**From:** Pagham Beach (Holdings) Ltd [<mailto:paghambeach@tiscali.co.uk>]  
**Sent:** 30 November 2011 11:37  
**To:** Planning  
**Subject:** Application ref: P/87/11 - 52 East Front Road, Pagham

**re. Town & Country Planning Act 1990**  
**Application ref: P/87/11**  
**52 East Front Road, Pagham**  
**Proposed extension to existing dwelling**  
**Re-submission following Application P/47/11**  
-----

Project	52 EAST FRONT ROAD, PAGHAM, BOGNOR REGIS WEST SUSSEX PO21 4ST	Drawn	sk	Project	126
For	Mr and Mrs Eysers	Scale	1:100 @ A3		
Title	SOUTH ELEVATION - PROPOSED 2011	Date	25.10.2011	Revision	d
				Drawing No.	P 06

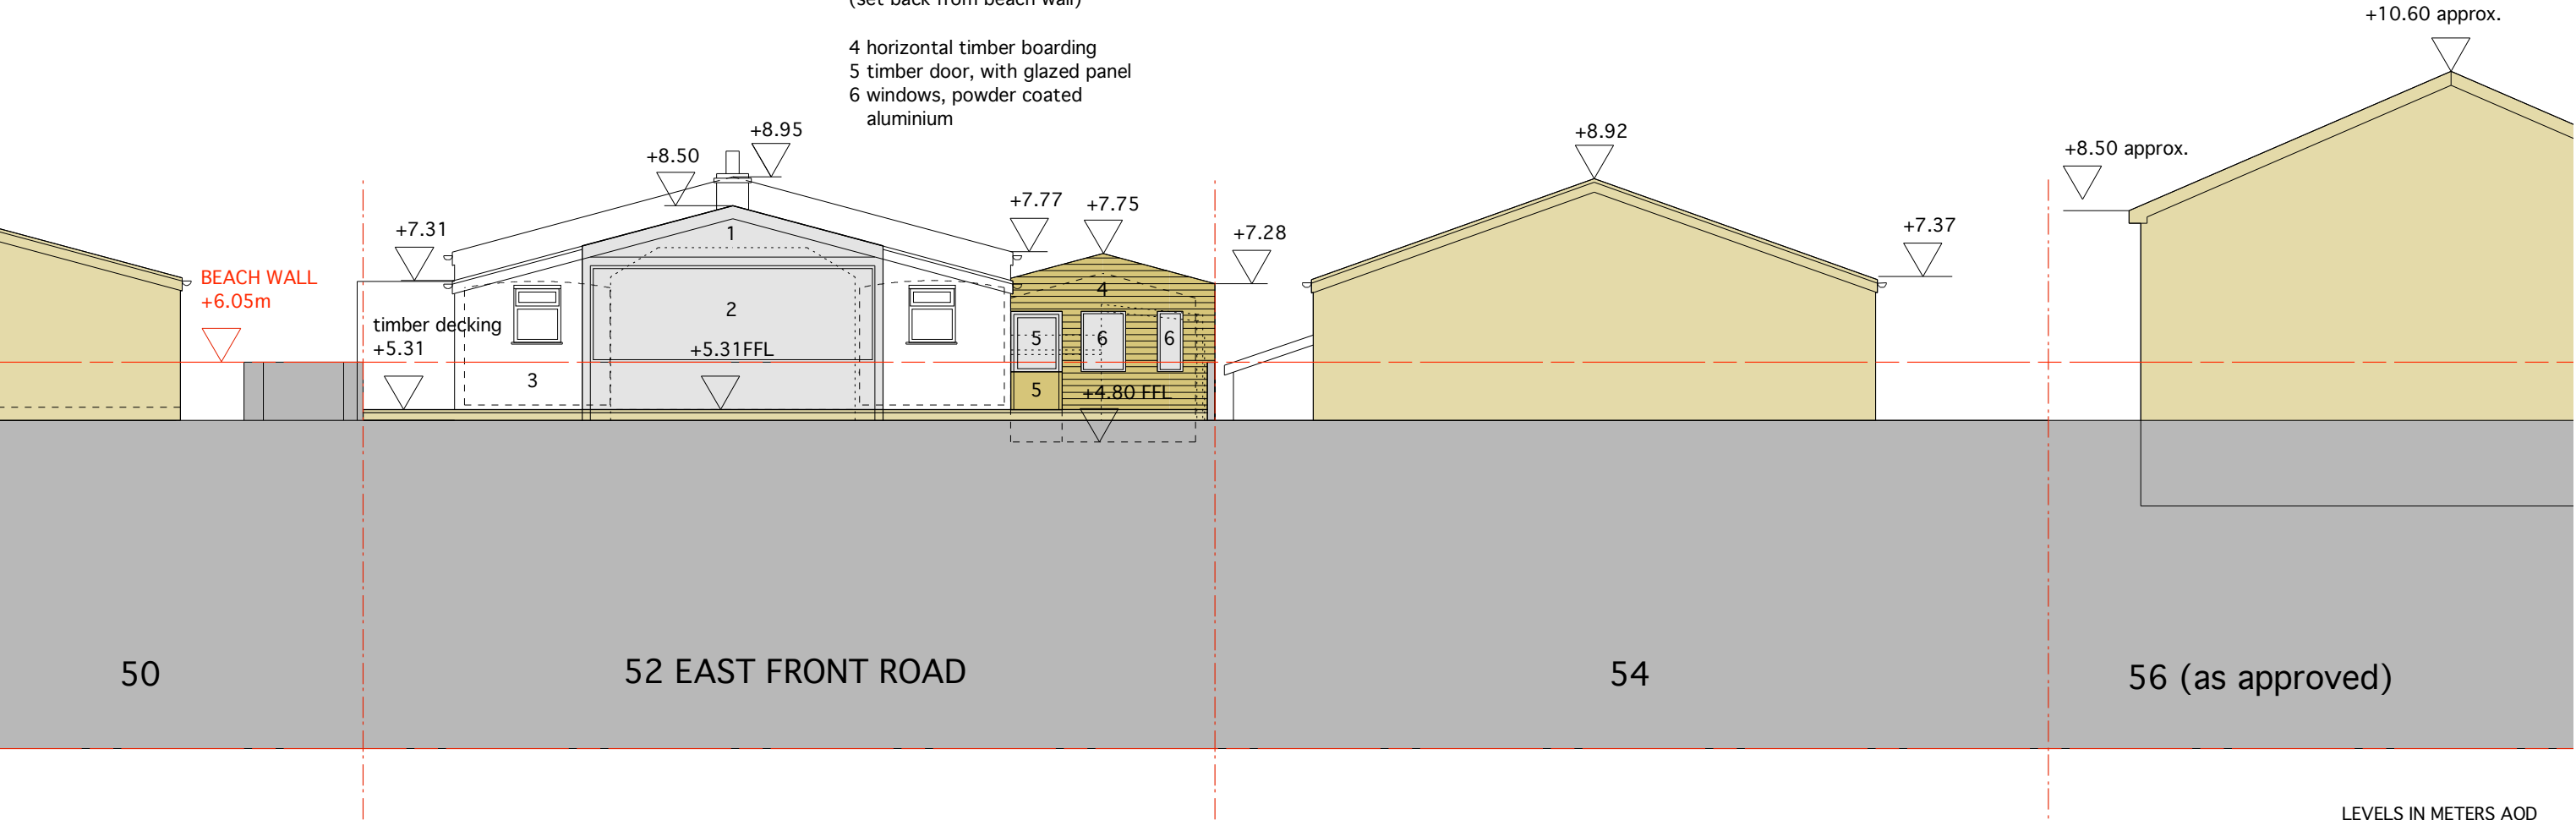
The appearance of the building is also completely inappropriate within this Area of Special Character and if allowed will create an extremely unwelcome precedent. As mentioned above, the proposal is contrary to Policy GEN7 and Area 1 of the Arun District Local Plan.

Project	52 EAST FRONT ROAD, PAGHAM, BOGNOR REGIS WEST SUSSEX PO21 4ST	Drawn	sk	Project	126
For	Mr and Mrs Eysers	Scale	1:100 @ A3		
Title	EAST ELEVATION AND SECTION A-A - PROPOSED	Date	25.10.2011	Revision	d
					Drawing No. P 07

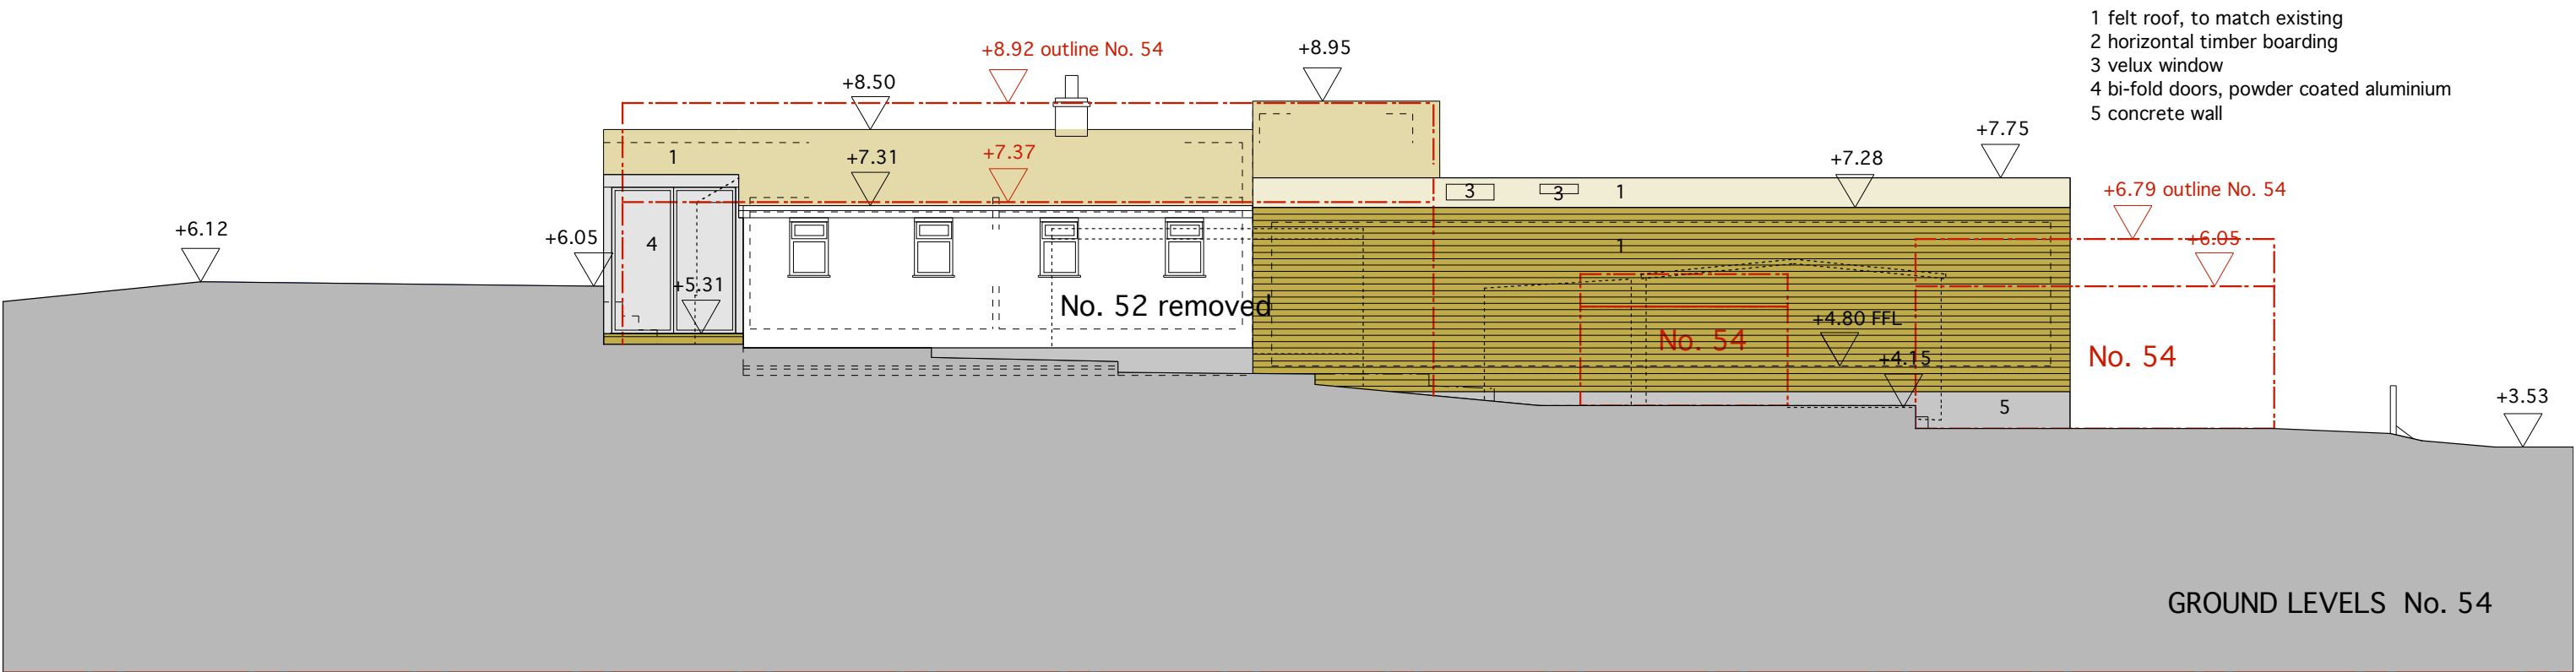
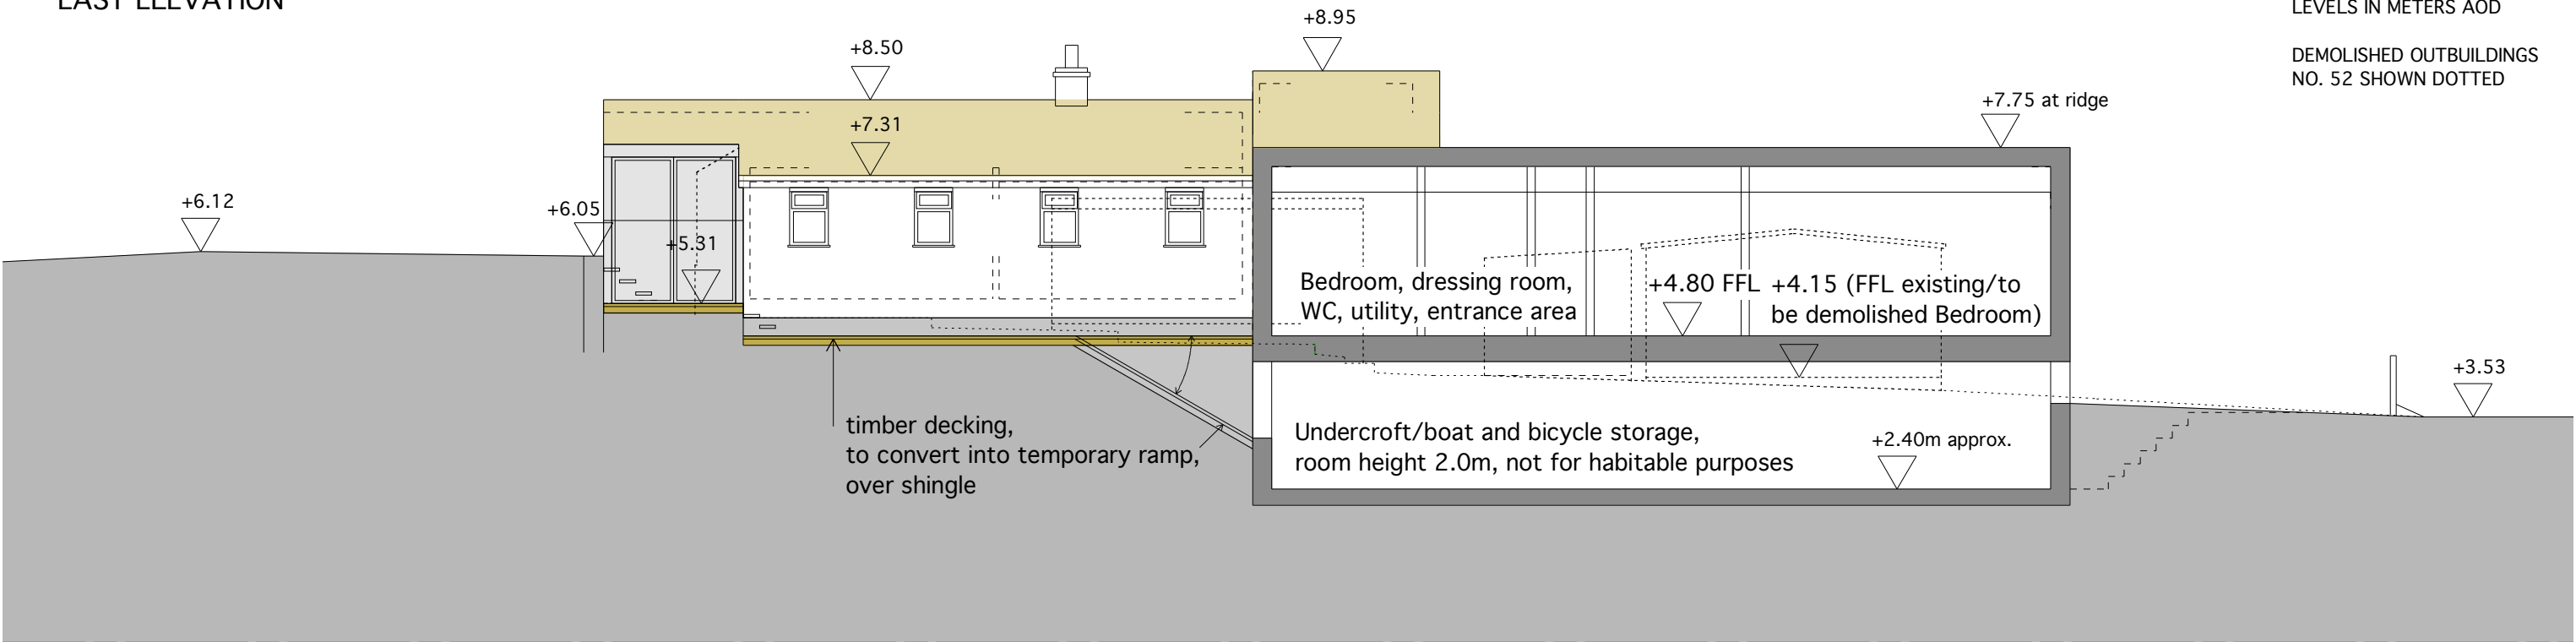
Despite amendment the proposed extension to the north of the original building remains a two-storey structure of basement and elevated ground floor accommodation, and proposes a structure of considerable bulk which it is hoped the Planning Authority would consider unacceptable within the street scene. The two-storey construction is also contrary to Local Plan Policies for the Beach Estate, and if Approved will create an unwelcome precedent.

The formation of a basement with a finished floor level as defined, proposed at 2.74 OAD is over 3.000 (10'0") below existing levels on the adjoining beach foreshore. This is completely inappropriate in this location and in the opinion of the Directors is verging on downright dangerous.

In order to achieve the construction at this depth, excavations to a depth of 12'0"-14'0" below beach level must be created, which in the shingle sub-strata will cause considerable local disturbance. The adjoining site and bungalow to the east must be protected and maintained stable and as a consequence a substantial retaining wall would need to be constructed on the boundary, to prevent collapse of the adjoining structure. These extensive civil works will be extremely damaging adjacent to a shingle foreshore already threatened by erosion from wave action and must be considered unwise and inappropriate.

The arrangement of the basement boathouse with a ramp down from the foreshore will definitely result in basement flooding with any over-topping event on high tide and/or storm conditions. This arrangement must surely be considered a completely unsuitable proposal which could endanger adjoining properties.

It should also be noted that the scheme proposes the installation of rooflights within the roof construction, which again is contrary to Local Plan Policies for the Beach Estate, and if allowed will create a precedent, which will undermine the Planning Authority's policies.

As a result of the considerable bulk of the building proposed it is also likely to create a serious overshadowing of the dwellings to the east, which again is unacceptable. In general the development is un-neighbourly and should be Refused by the Planning Authority.
